Application by Springwell Energyfarm Limited for an Order Granting Development Consent for the Springwell Solar Farm

Issue Specific Hearing 1

Date: 8 May 2025

Action Points:

Plate 3.1: Environment Agency Flood Zones (model layer from Defra) – Whole site (full map in Appendix B.2)

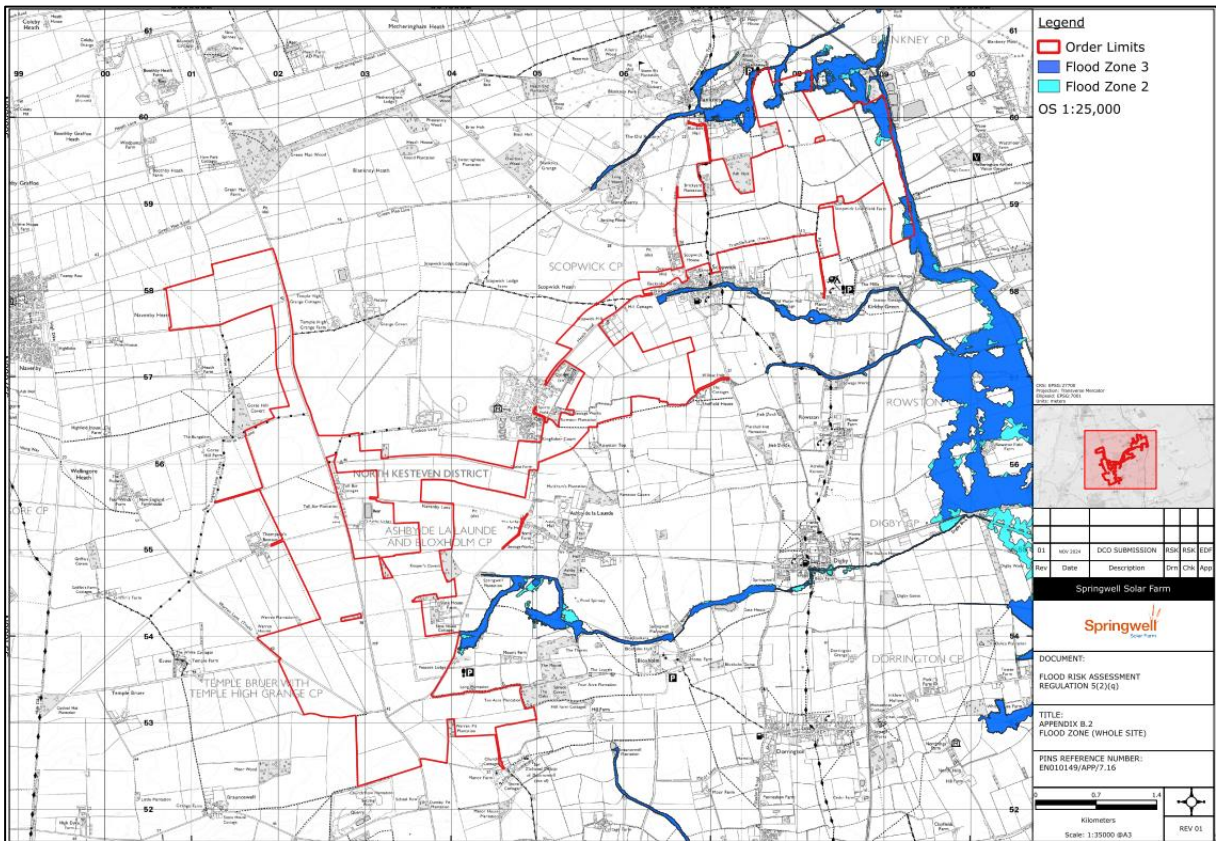
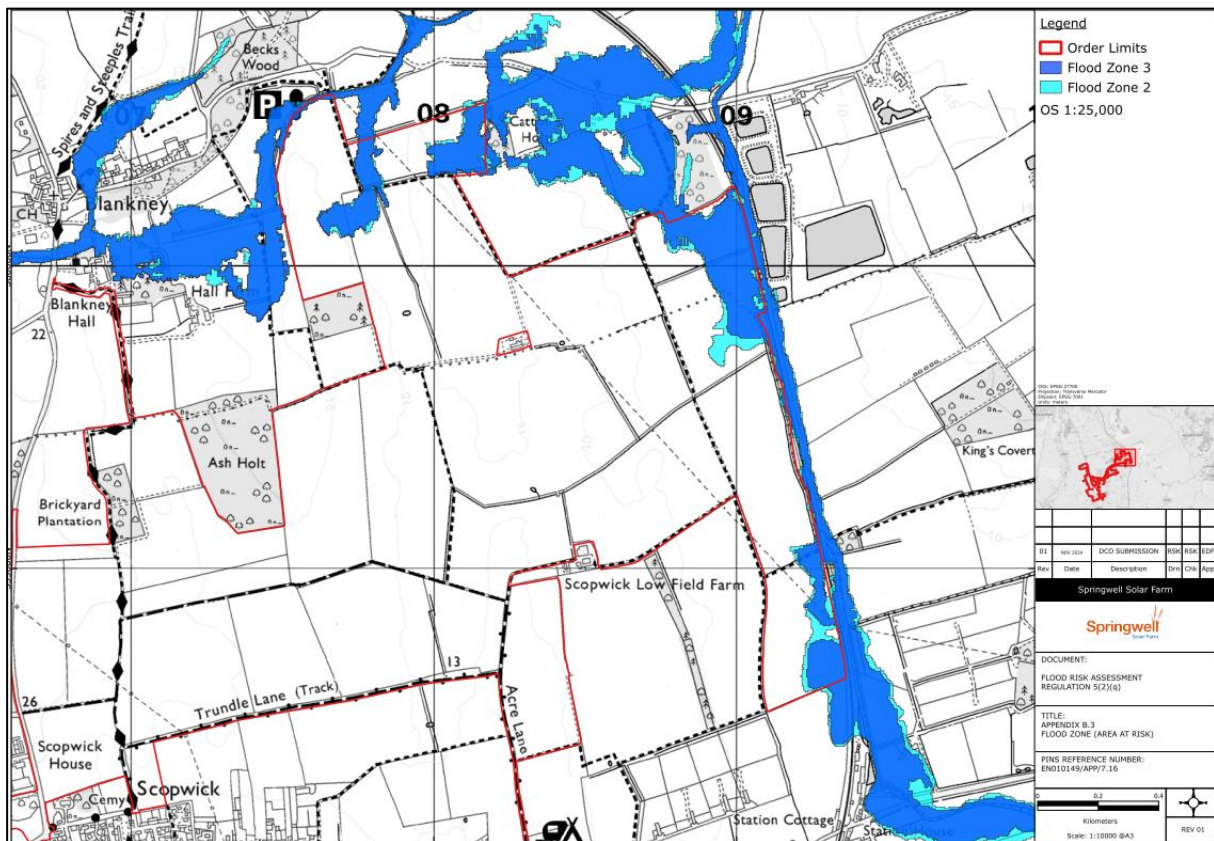
No.	Party	Action	Deadline
9	Applicant	Provide updated flood risk assessment following new flood and coastal erosion risk data that has been published by the EA.	D1
10	Applicant	Provide written submission to explain why Solar PV modules must be located in Flood Zone 3b for operational reasons and a map with supporting evidence that demonstrates why it is not possible for Solar PV modules to be located in areas of Flood Zone 1 either within the Order limits or directly around it.	D1
11	Applicant	To provide further evidence to demonstrate that the suggested 'fallback' extant permission for the solar farm on the application site is directly comparable to the Proposed Development and would be delivered if the Proposed Development were to be refused development consent.	D1
12	Applicant	Provide the revised wording for the dDCO requirement 11 along with an update on discussions with LCC and HE.	D1
13	NKDC	To set out in LiR which above ground heritage assets that have not been scoped into the assessment should be and why.	D1

DRAWING TITLE:
PROPOSED HIGHWAY IMPROVEMENTS

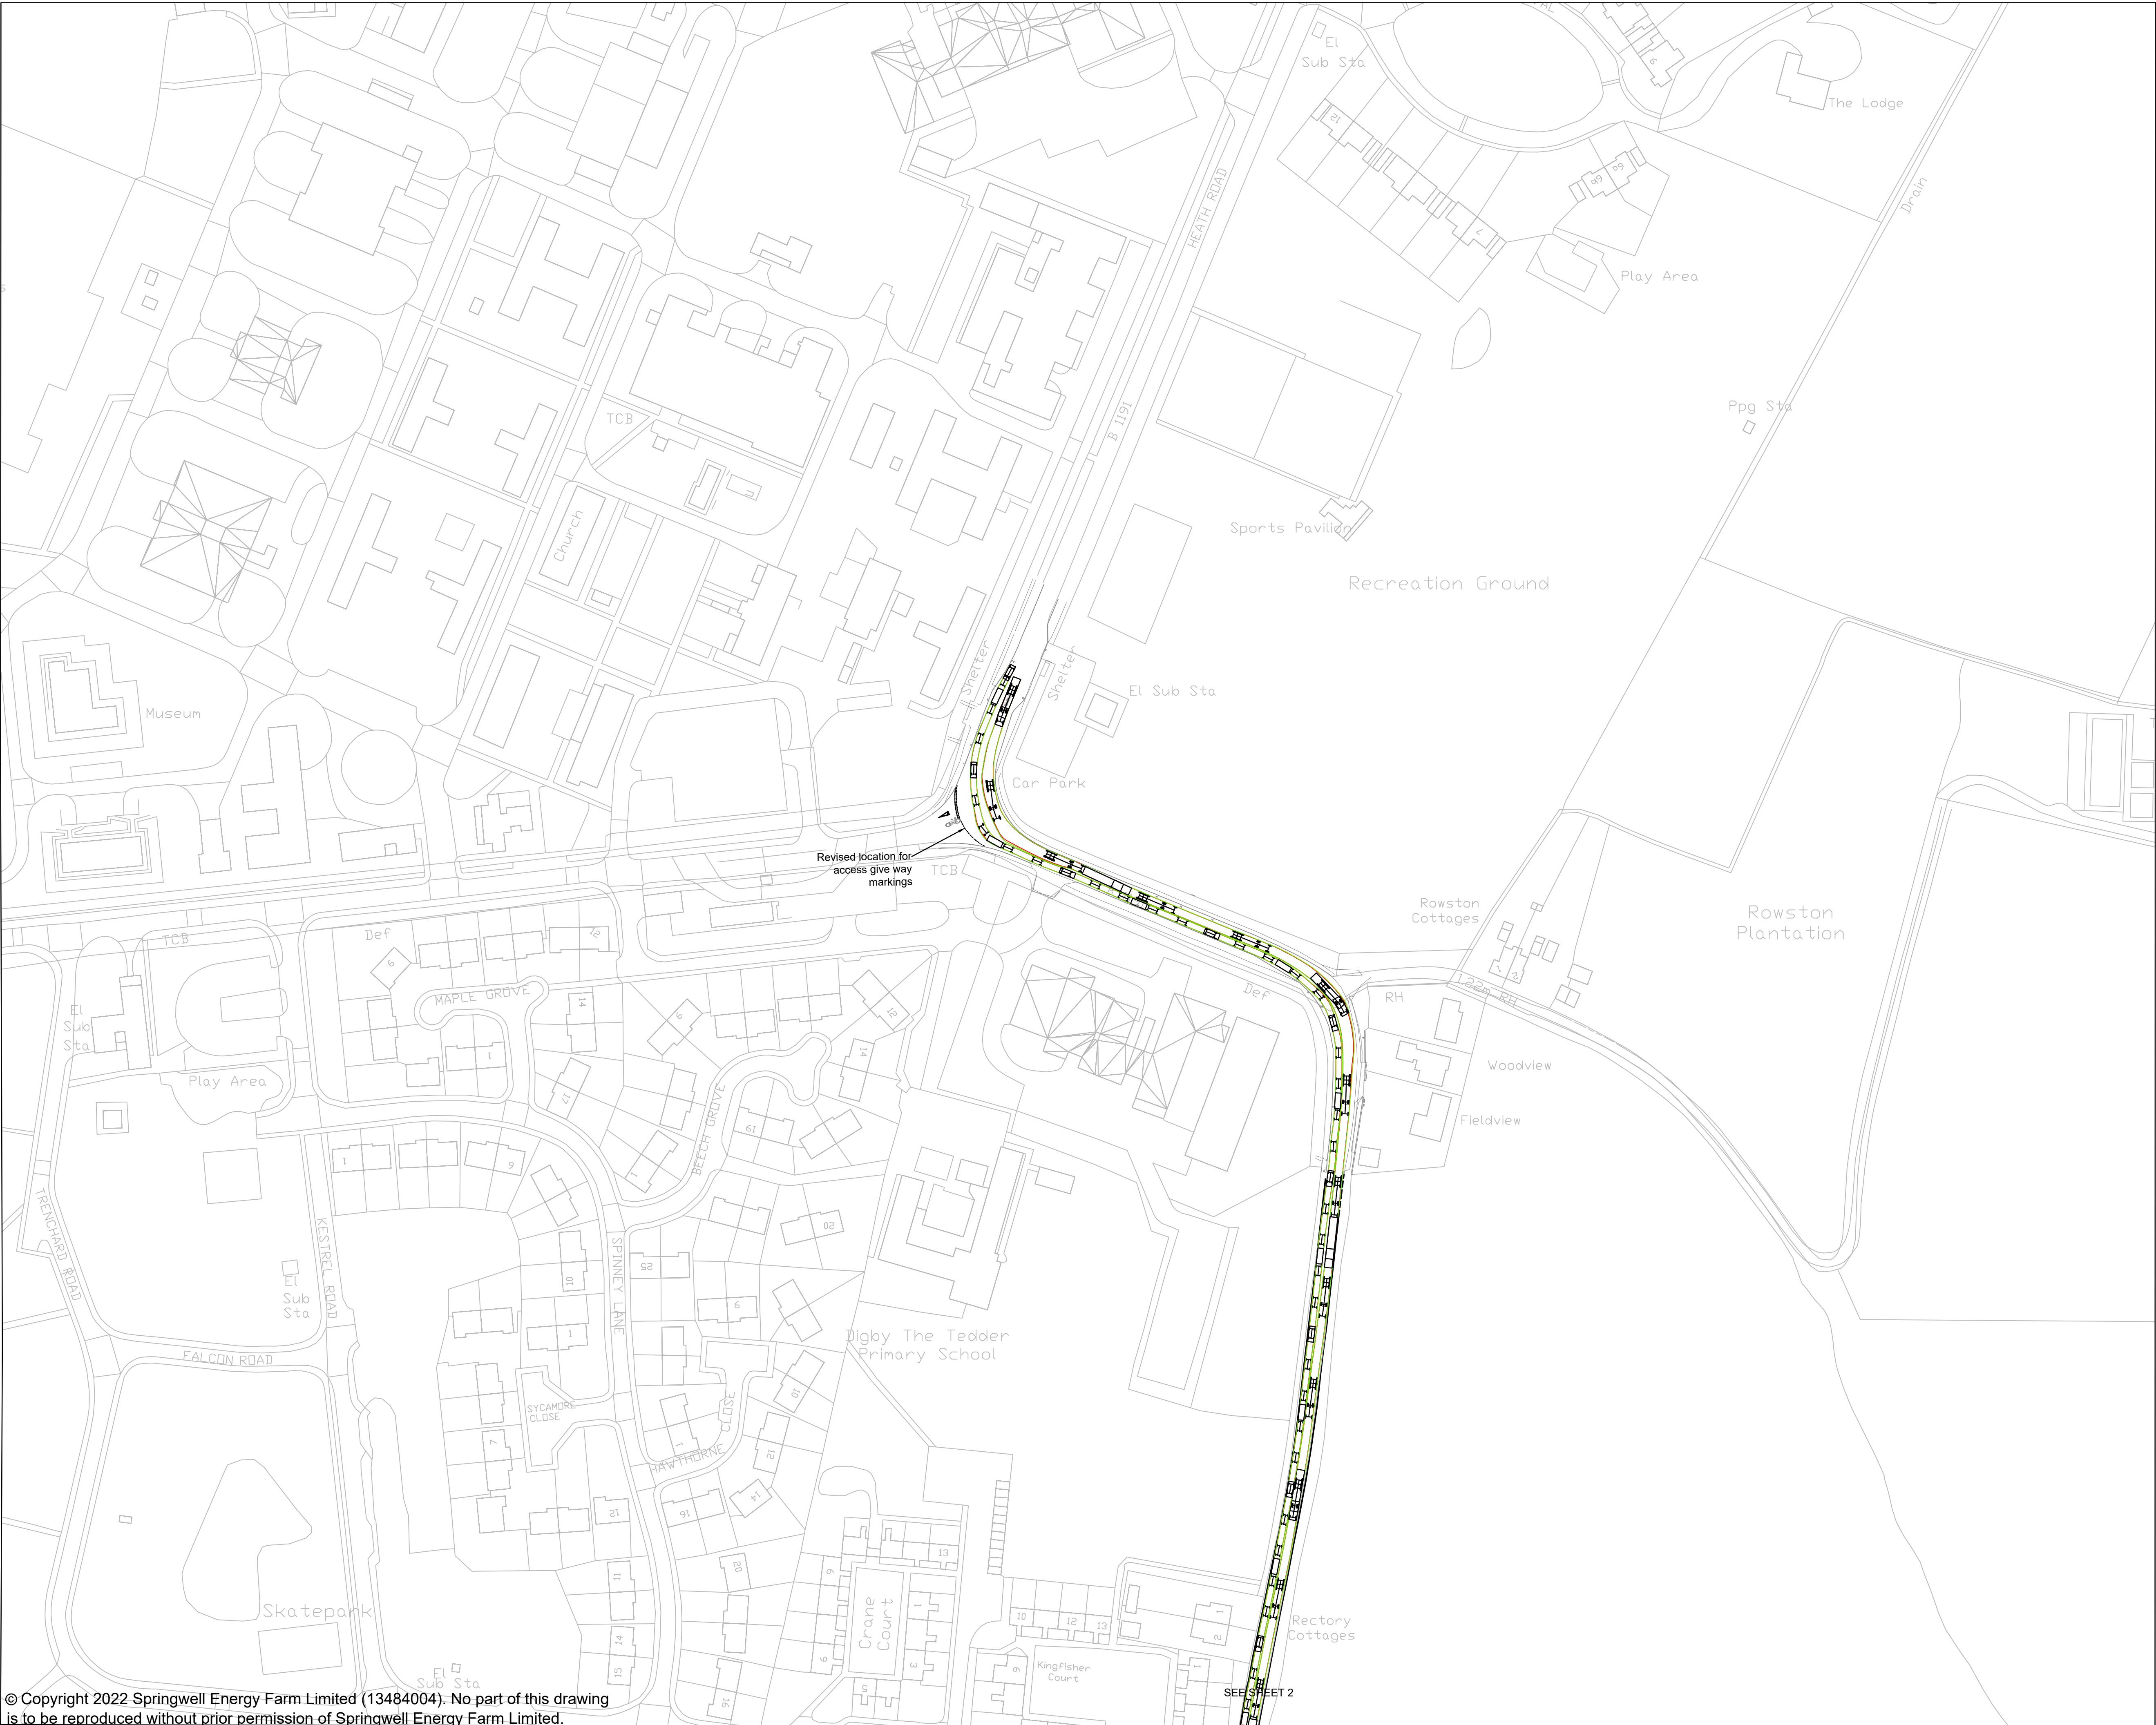
7	Applicant	Provide the Stage 1 Road Safety Audits of the indicative junction improvement schemes referred to in the ES.	D1
8	Applicant	Applicant to revise application documentation to ensure that LCC sign off any highway improvement works.	D1
